City of Portland, Maine – Building or Use Permit Application 389 Congress Street, 04101, Tel: (207) 874-8703, FAX: 874-8716

Proposed Project Description: Remove approx 25 linear feet on non bearing partitions Reinstall approx 25 linear feet of partition Rew suspended ceiling, tile floor, paint, etc.						37-14-25 PERMIT ISSUED WITH REQUIREMENTS	
Permit Taken By: MG		Date Applied For: 02 July 1998				Zoning Appeal <input type="checkbox"/> Variance <input type="checkbox"/> Miscellaneous <input type="checkbox"/> Conditional Use <input type="checkbox"/> Interpretation <input type="checkbox"/> Approved <input type="checkbox"/> Denied Historic Preservation <input type="checkbox"/> Not in District or Landmark <input type="checkbox"/> Does Not Require Review <input type="checkbox"/> Requires Review Action: <input type="checkbox"/> Approved <input type="checkbox"/> Approved with Conditions <input type="checkbox"/> Denied Date: [Signature]

BUILDING PERMIT REPORT

DATE: 7/6/98 ADDRESS: 57 Oak St
REASON FOR PERMIT: renovation
BUILDING OWNER: Bahman Nikooghos
CONTRACTOR: Spice Pyer
PERMIT APPLICANT: _____
USE GROUP B BOCA 1996 CONSTRUCTION TYPE 3.B

- 1 CEILING 9 FT SUSPENDED
- 2 2x4 AND 2x6 WOOD FRAME PARTITION
- 3 1/2" DRYWALL FINISH TAPED
- 4 NEW FLOORING INTERLOCK CERAMIC
- 5 RELOCATE HAND SINK
- 6 INSTALL CLOTHES WASHER

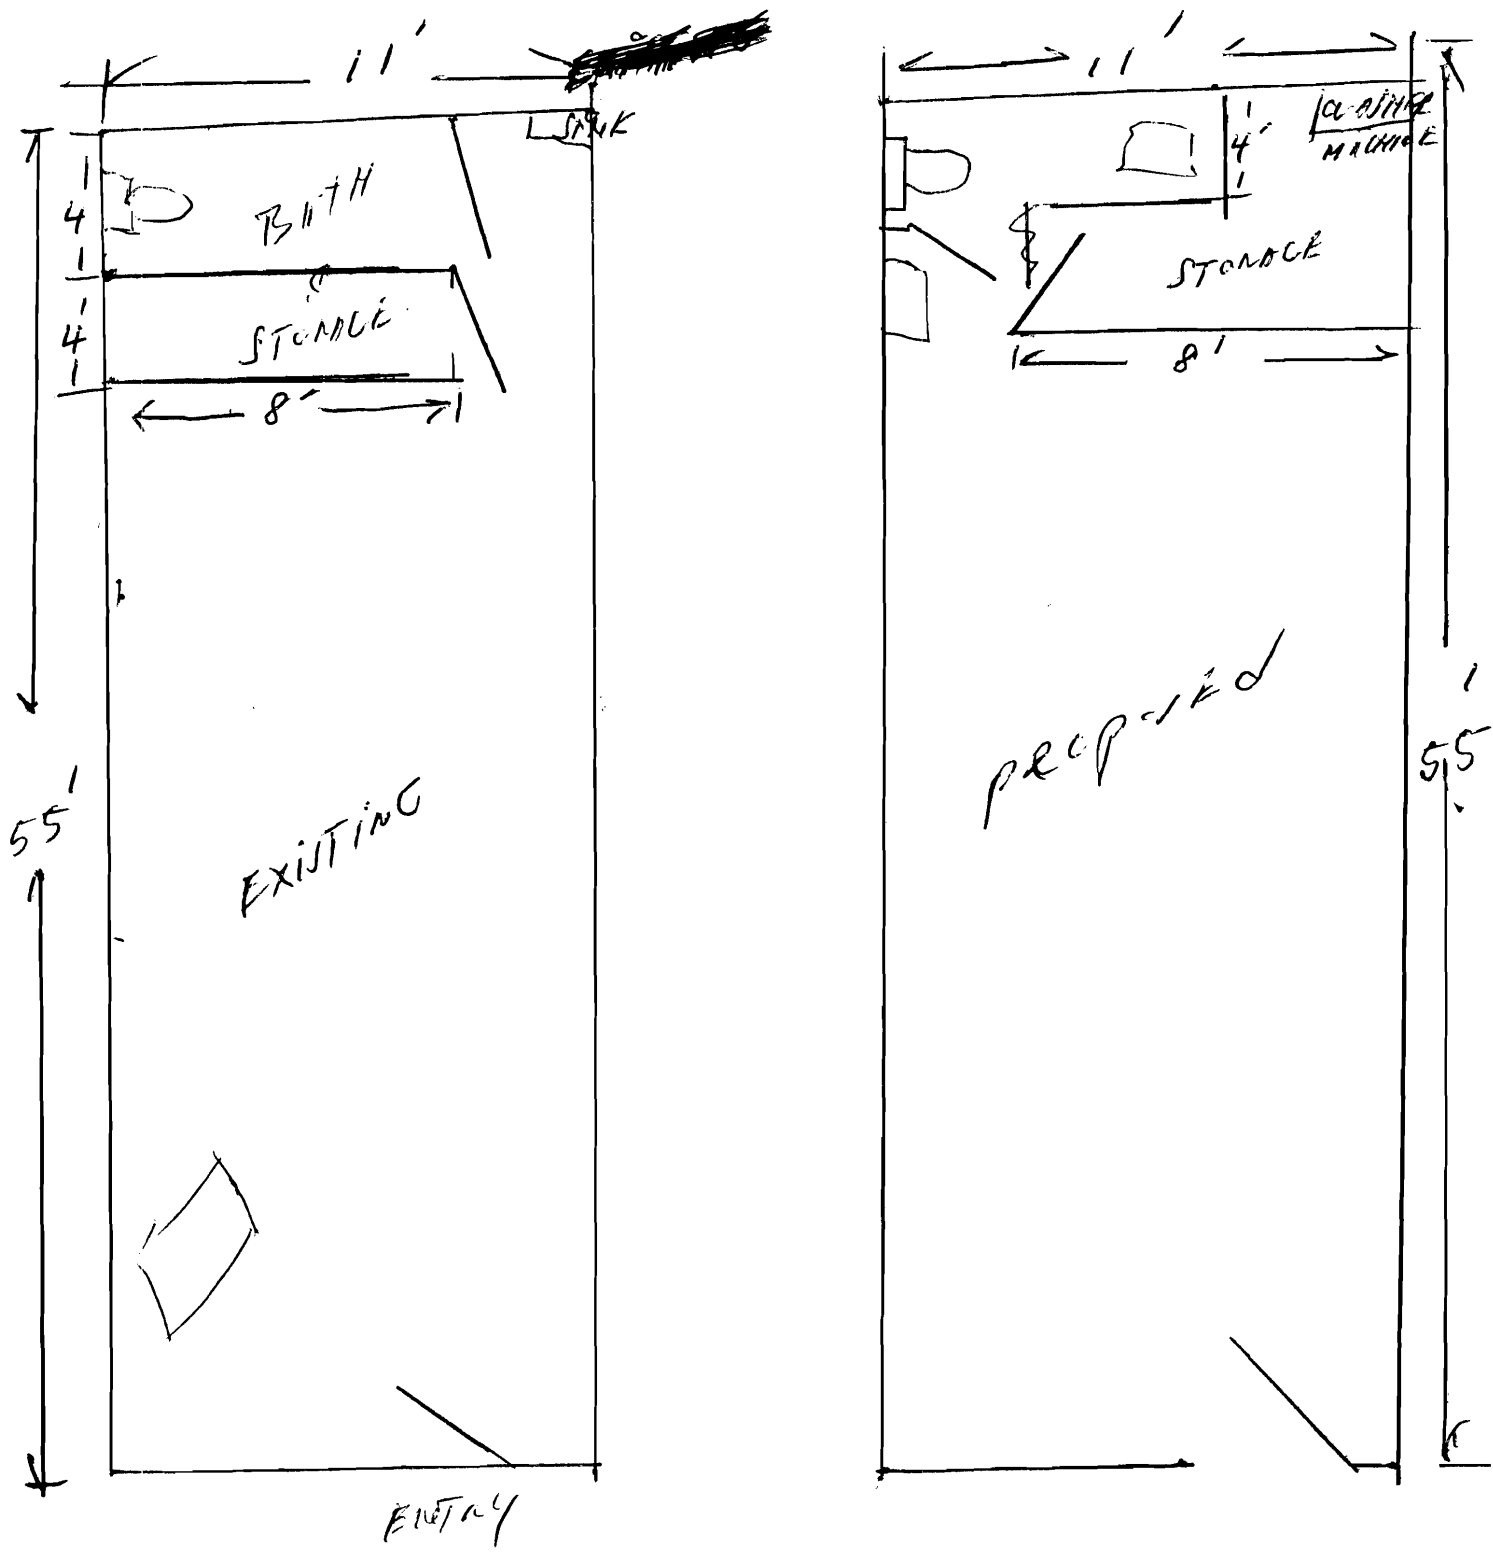
- * 29. Any holes in old ceiling holes must be patched before installing new ceiling.
